Objection

Planning application: 2025/91606

Development: Change of use of outbuilding and land to dog hotel

**Location: Reservoir House, Whitley Road, Whitley, Dewsbury,
WF12 0NQ**

**SITE LOCATION PLAN**  
**AREA 2 HA**  
**SCALE 1:1250 on A4**  
**CENTRE COORDINATES: 421850, 417685**

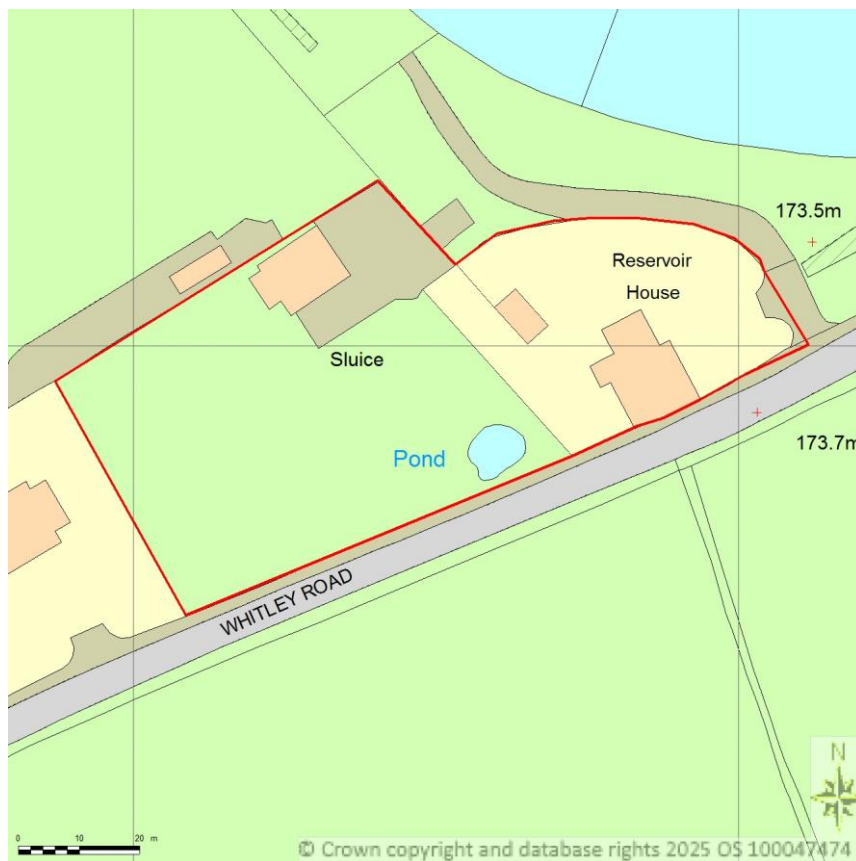
The location plan (document 1092325) is so limited in area as to show only the application site. All residential properties within the village of Whitley that stand to be affected have been excluded - including the length of Whitley Road between the houses at Beebow and the former Woolpack Inn, and also along Scopsley Lane from its junction with the former Woolpack Inn.
